Date: 22 November 2019

Application by ScottishPower Renewables for an Order Granting Development Consent for the East Anglia TWO Offshore Wind Farm

Advice following issue of decision to accept the application for examination

Land Plans (Onshore)
Sheet Number: Sheet 2 of 12

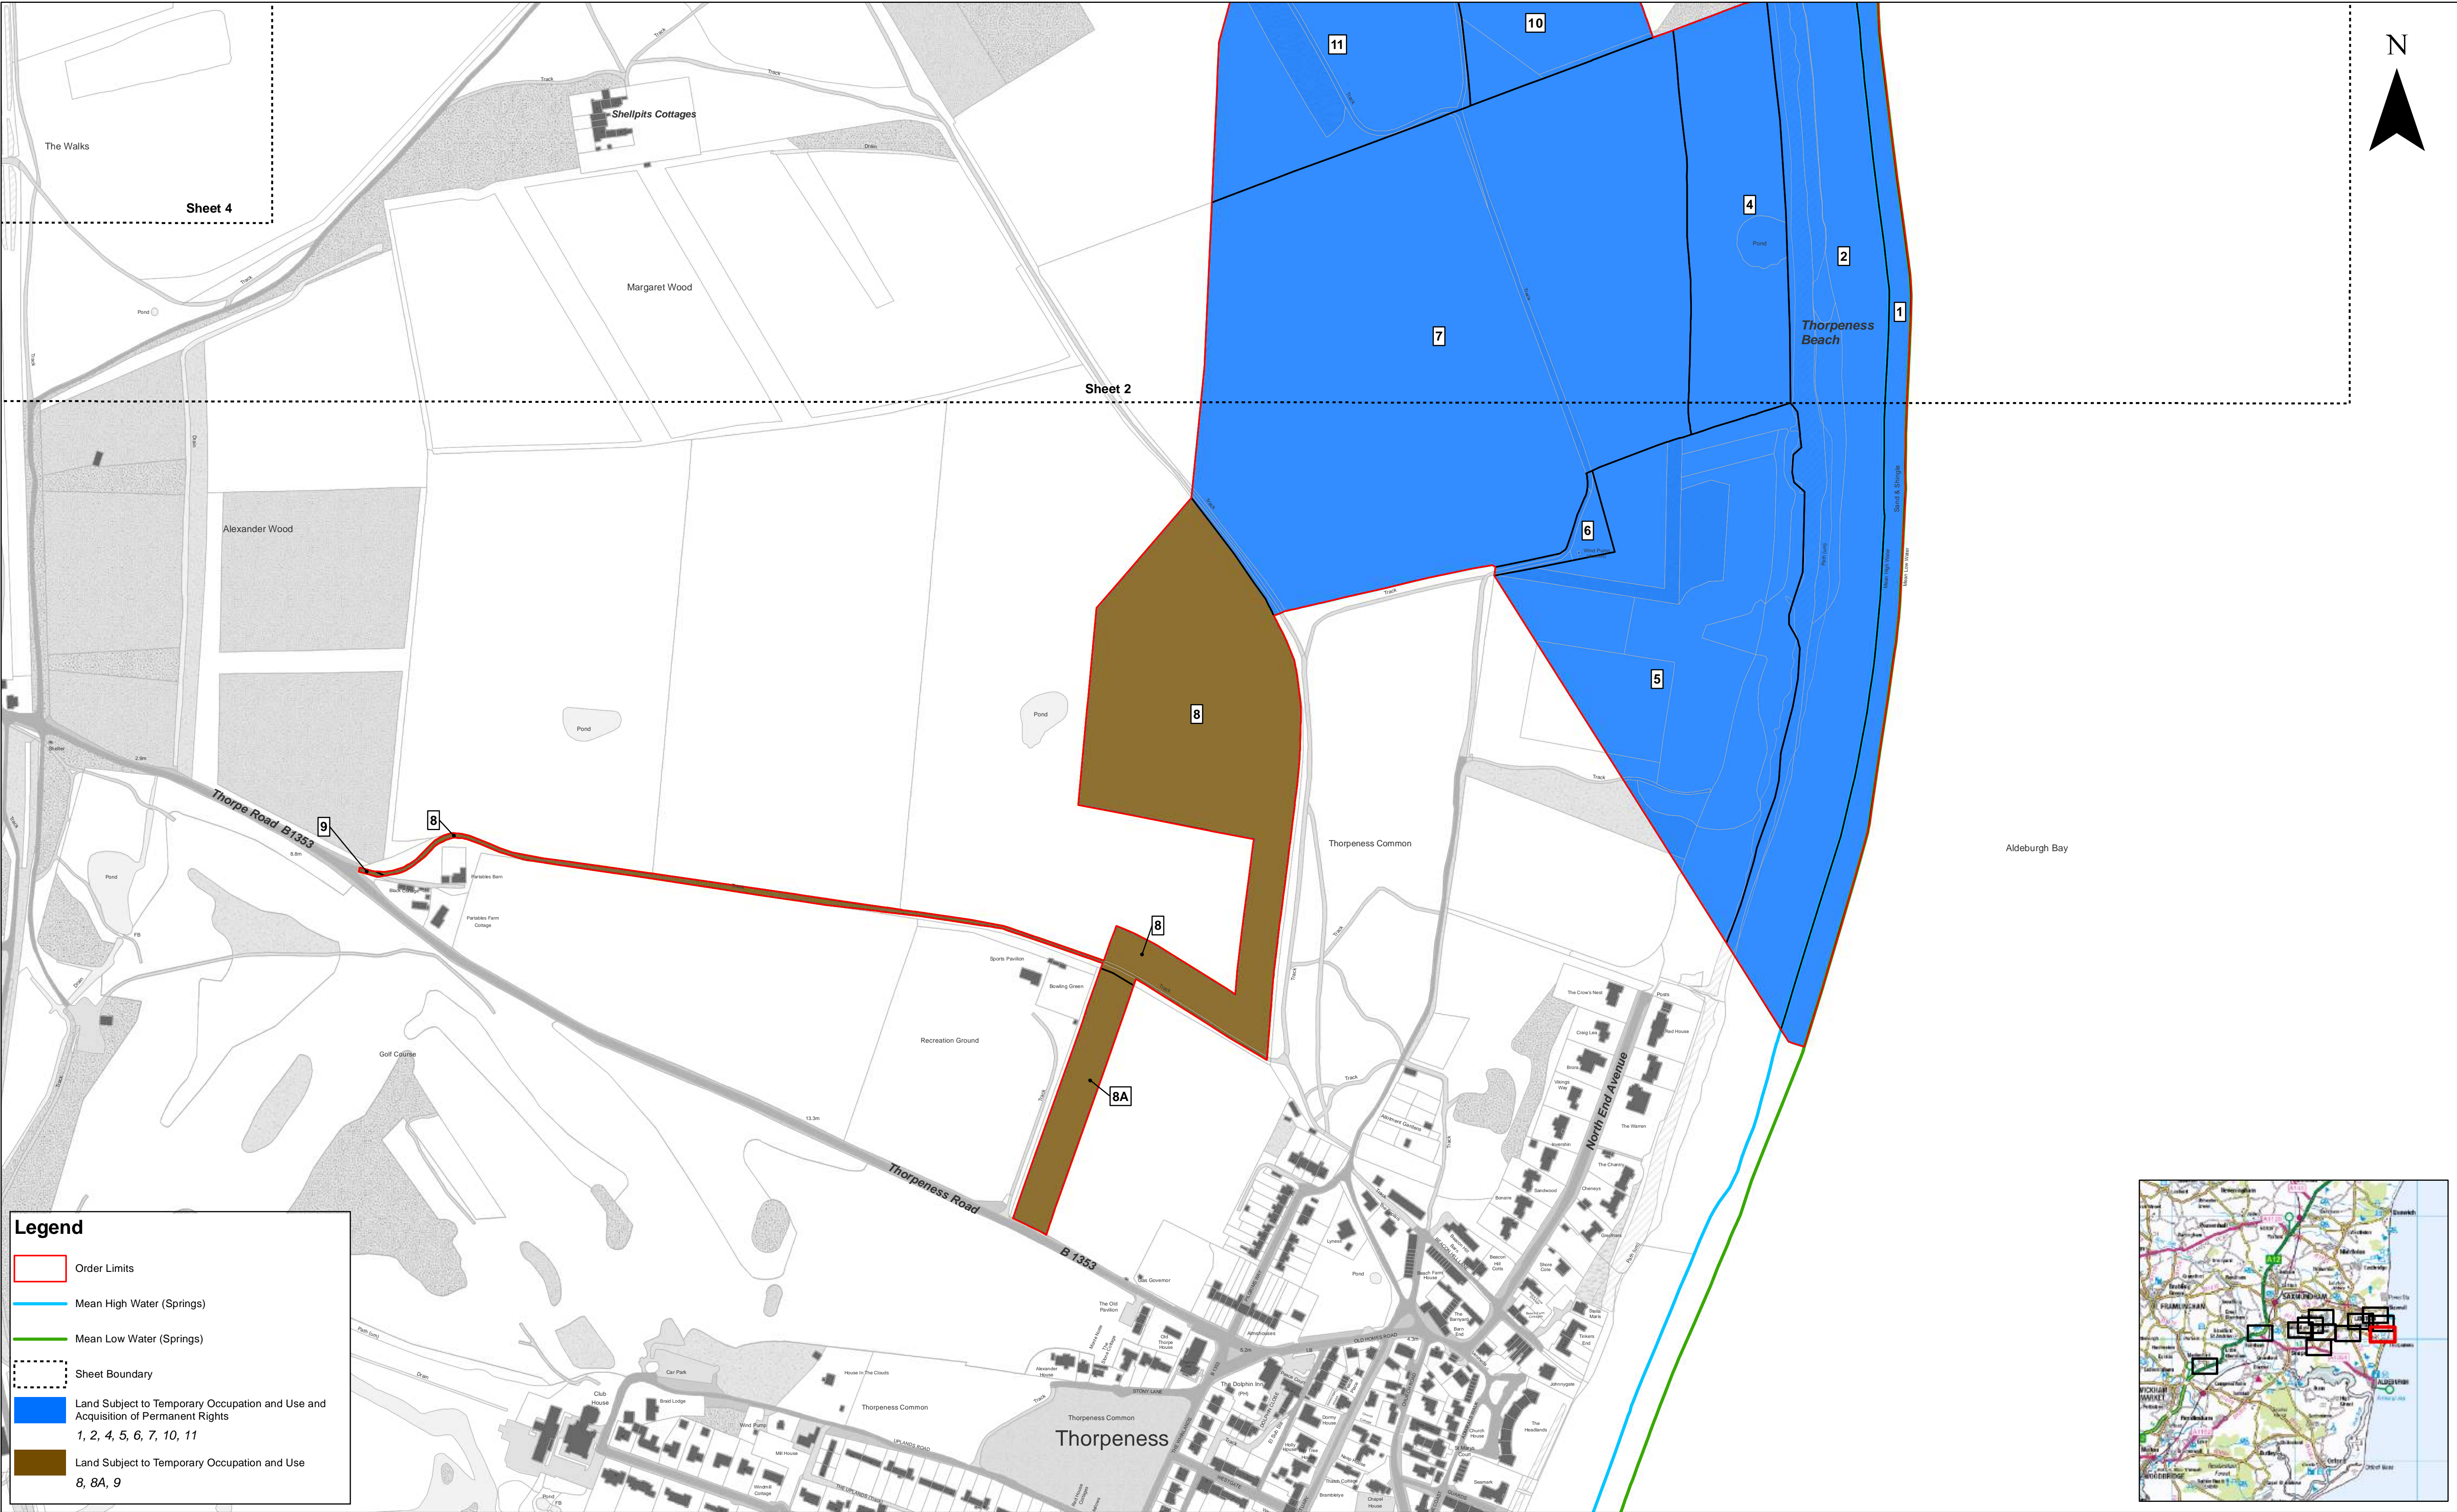
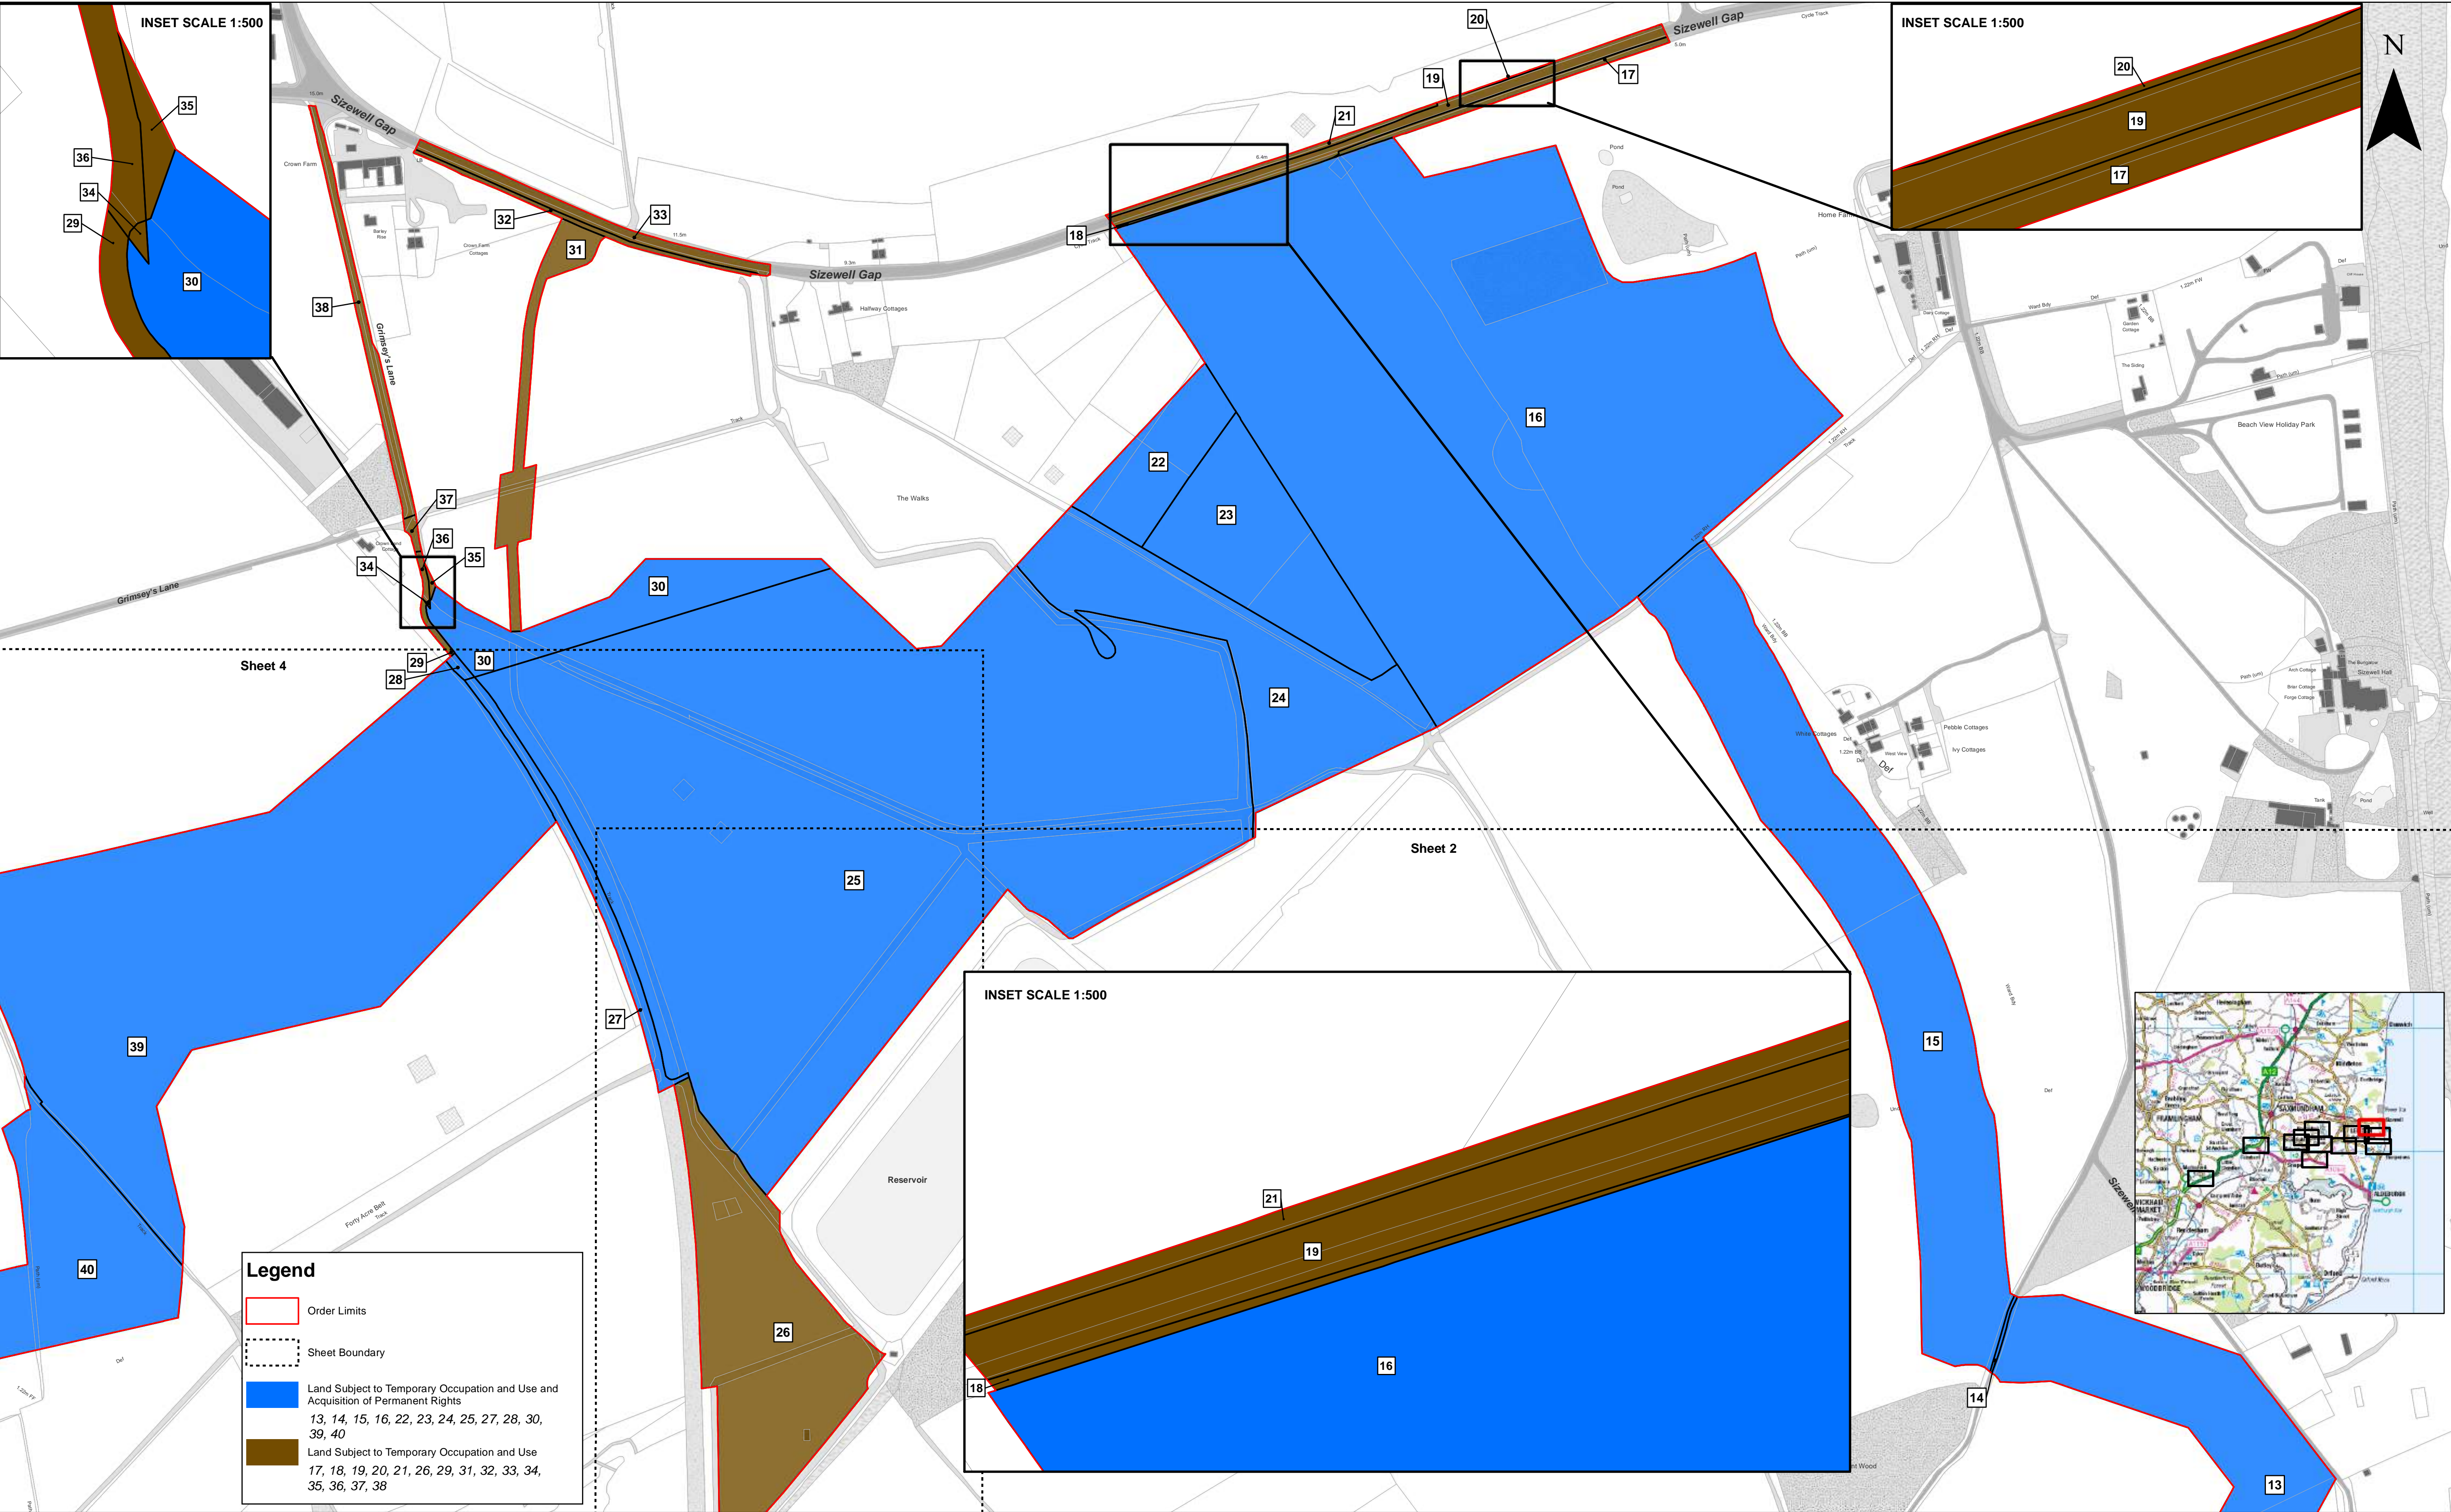
Please provide updated Land Plans which include:

- The names of all relevant landmarks described in Column 2 ('Extent of acquisition or use') of the BoR (e.g. Sizewell Estate, Sizewell Gap, Grimsey's Lane, Blackheath Estate, Redhouse Farm and Knodishall Hall) should also be shown on the relevant Sheets of the Land Plans.

- Road names on the Land Plans to assist the identification of land should be shown more clearly.
- Larger and clearer landmarks on the relevant Sheets of the Land Plans.

- The same map base as the other submitted plans and sheet layout. (It was noted in the checklist that the Land Plans have used a different map base to the other submitted plans, and this makes comparison between the Land Plans and the other submitted plans more difficult than it needs to be.)

- Additional insets. (It was noted in the checklist that Plots 18, 91 and 126 would benefit from being shown on an inset plan.)
- Corrected Plot number for inset 9.4.
